Final Acceptance Punchlist
El Paso County – Department of Public Works - Stormwater Section

Project Name:	Jackson Ranch F4
EDARP Filing Number(s):	SF17-016
ESQCP Number:	ESQ197
Attendees:	DPW SW: Molly Layshock, Ben Jones DPW Development Services: Brad Walters Developer: Marlene Brown
Date of Walk-Thru:	10/02/2023
Walk-Thru Number:	1 st

JACKSON RANCH COURT

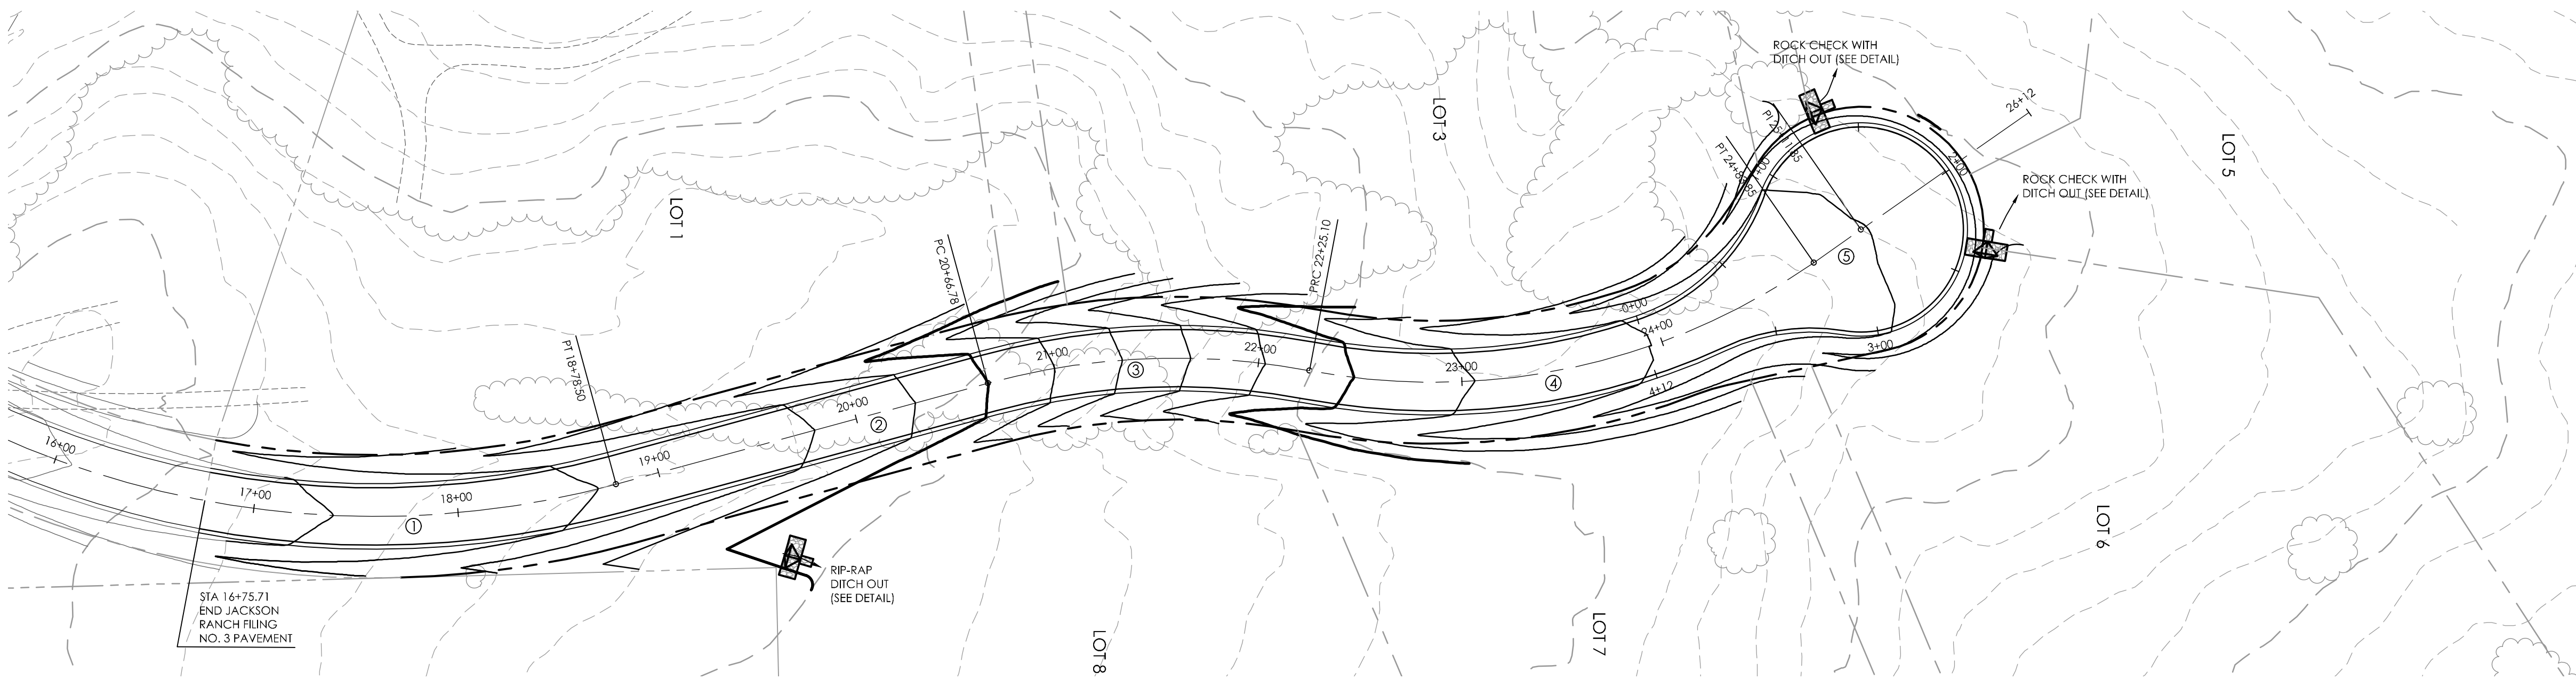
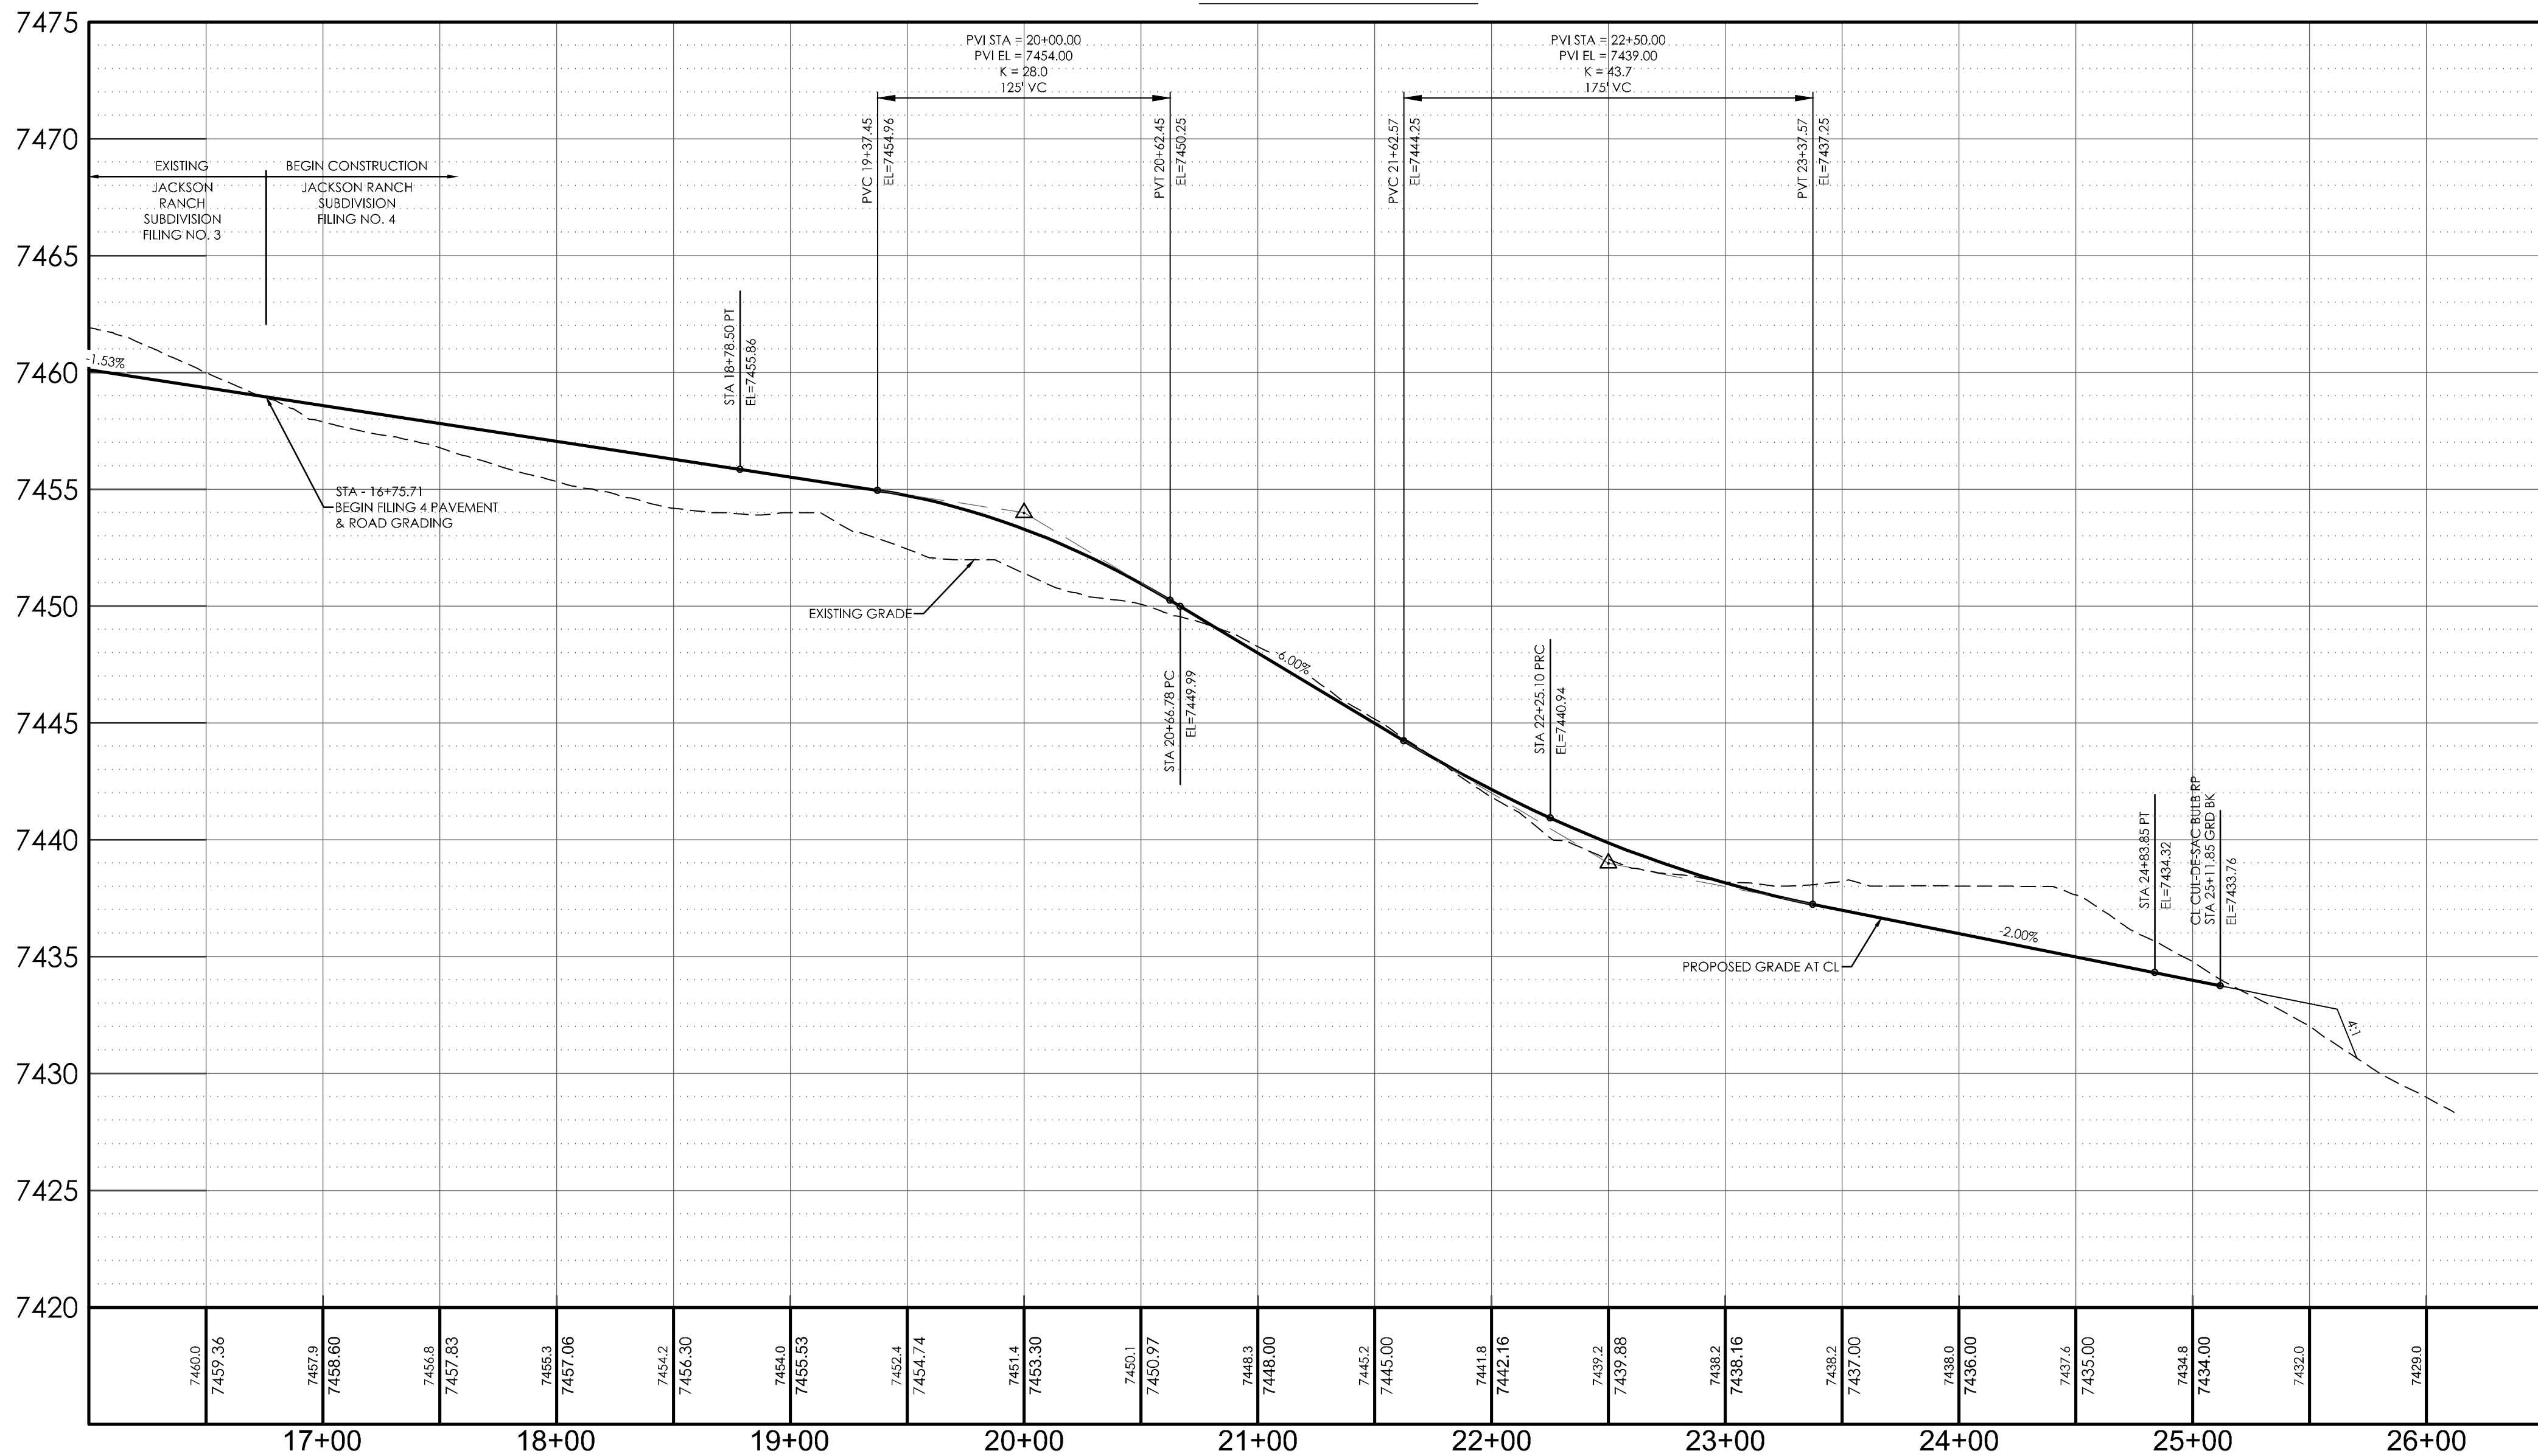
- Regrade Jackson Ranch Ct shoulder erosion per detail on both sides of the road (Photos 1 and 2)
